Recommendation Report for Planning Permission

REF NO: BR/233/19/PL

LOCATION: 77 Aldwick Road
Bognor Regis
PO21 2NW

PROPOSAL: Part change of use of ground floor & formation of a first floor rear extension to create 2 No self-contained studio flats with associated refuse/ recycling & cycle store (resubmission following BR/63/18/PL).

REAR
PROPOSED ELEVATIONS
Scale 1:100

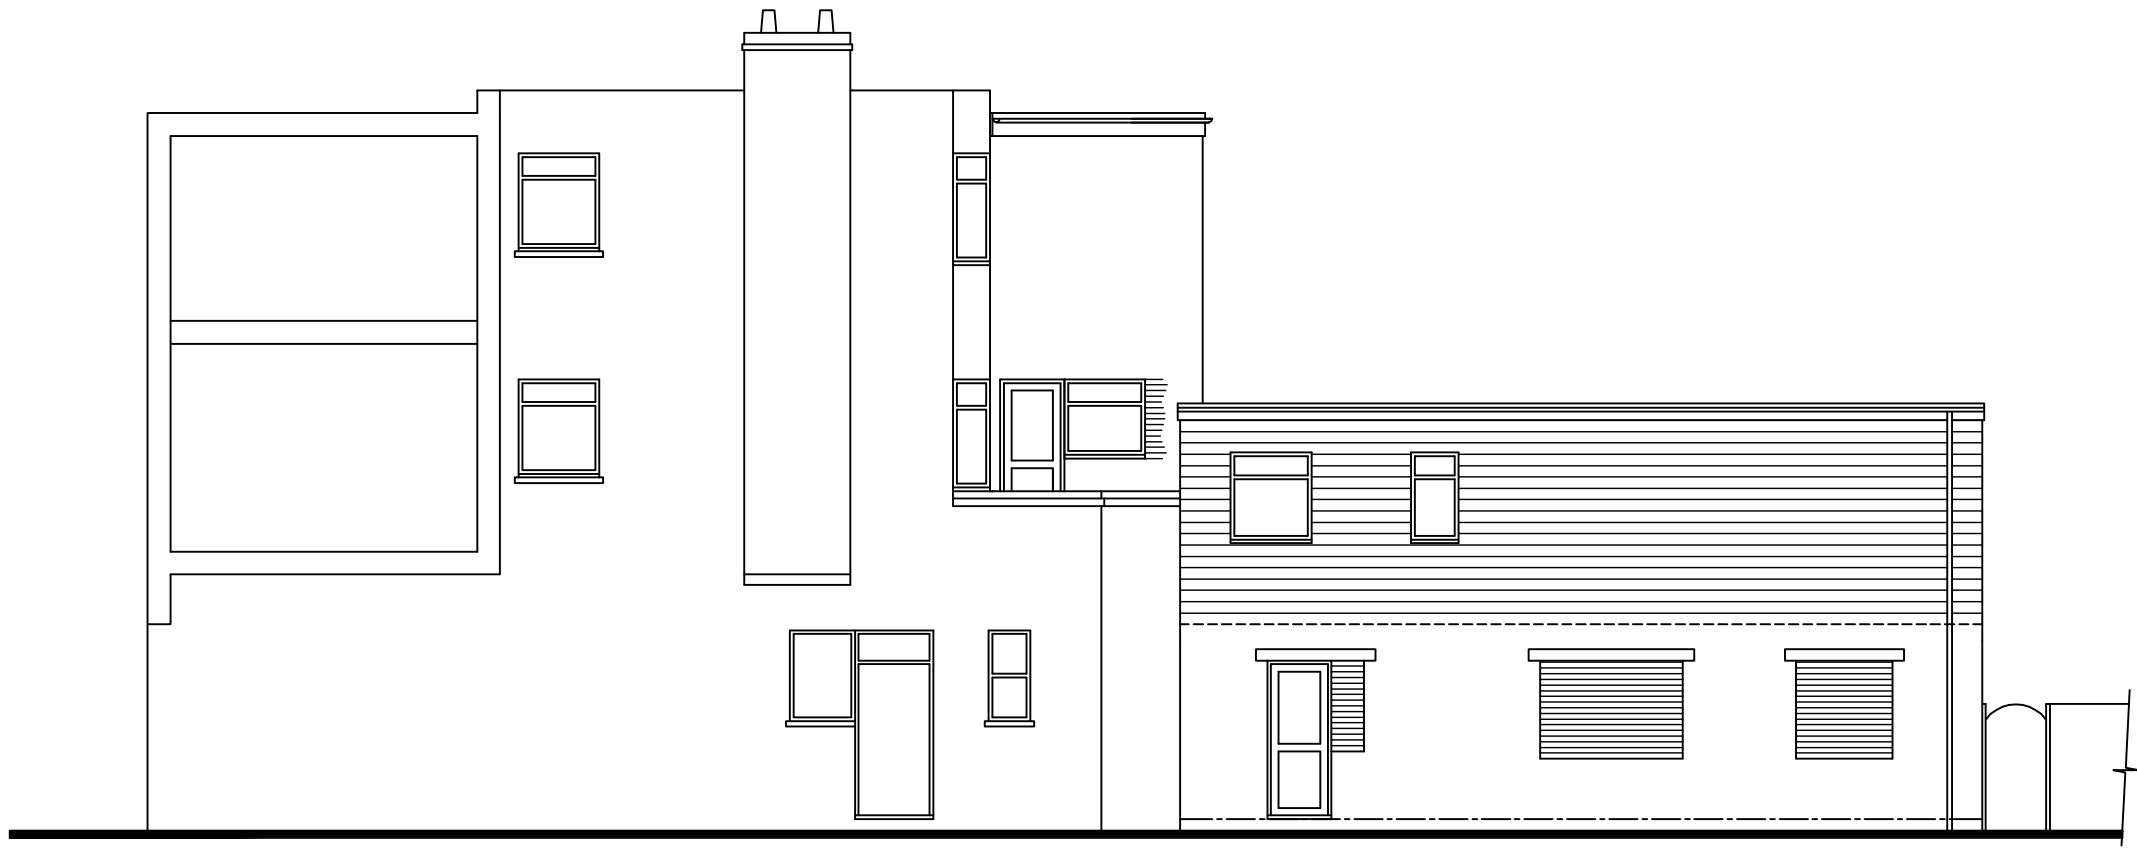
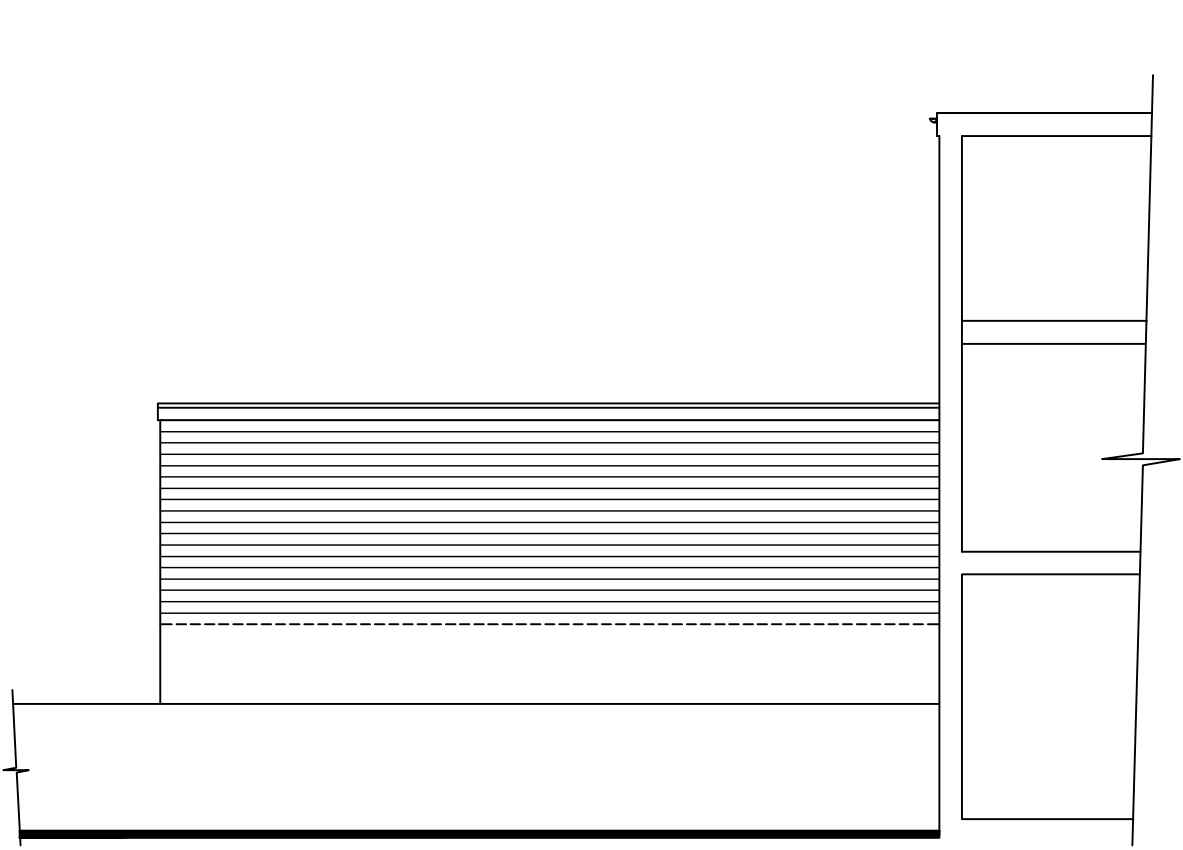
The first floor rear extension would comprise c. 1.5m of additional height and would feature a flank wall abutting the terrace area of the first floor apartment at 77 Aldwick Road. It was noted that residential paraphernalia was present which is indicative of an intense use of this balcony space. Whilst being in the vicinity of adjacent development, there is no development physically abutting this terraced area at present which provides an open aspect. This open aspect is characteristic of the rear of first floor apartments in this area. This character is similar to the terrace attached to the first floor apartment of no. 79 Aldwick Road.

The development would abut the terrace of no. 77 with a flank wall of c. 1.5m high and would enclose the southern aspect of this already limited outdoor amenity space of no. 77. Such a level of enclosure would be uncharacteristic and would be harmful to the limited private amenity space afforded to residential properties in such a location. The first floor extension would also be located c. 2m from the first floor terrace of no. 79 Aldwick Road. The development would be at the same height as the terrace and would also feature windows along the elevation obliquely facing the first floor terrace of no. 79. This proximity to the terrace of no. 79 would result in an undue sense of enclosure that demonstrably harms the level of amenity afforded to the first floor apartments at nos. 77 and 79 Aldwick Road.

The development would result in a visual sense of enclosure owing to the close 3m relationship to nos. 75, 77 and 79, combined with the height of c. 1.5m metres from first floor levels. This would materially affect the primary living accommodations of the adjacent first floor apartments (nos. 75, 77 and 79) and would result in a tunnel effect on the existing occupants of the 3 no. residential properties. Such a design results in harm to the amenities of neighbouring occupiers.

Whilst the reduction in height following application BR/63/18/PL has been welcomed, the proposed windows along the western elevation of the first floor studio apartment would result in an level of intervisibility between occupants of apartments of no. 79 Aldwick Road and the occupants of the first floor studio apartment. In its submitted form this relationship would be considered unacceptable due to the perception of overlooking. It is noted that these western windows serve hallways and non-habitable living spaces and could therefore be overcome by way of condition requiring obscure glazing.

1 The height and scale of the proposed additional first floor extension to the rear of 77 Aldwick

Road will result in an overbearing impact on, and loss of outlook to, the amenity of the existing windows of the first floor residential flats in the rear of 75 - 79 Aldwick Road. In the absence of a full BRE sunlight/daylight study there Local Planning Authority has not been satisfied that there will not be a demonstrable harmful loss of sunlight/daylight to neighbouring residential properties. The proposal is therefore contrary to policies D SP1, D DM1, D DM2 and QE SP1 of the Arun Local Plan and the National Planning Policy Framework.
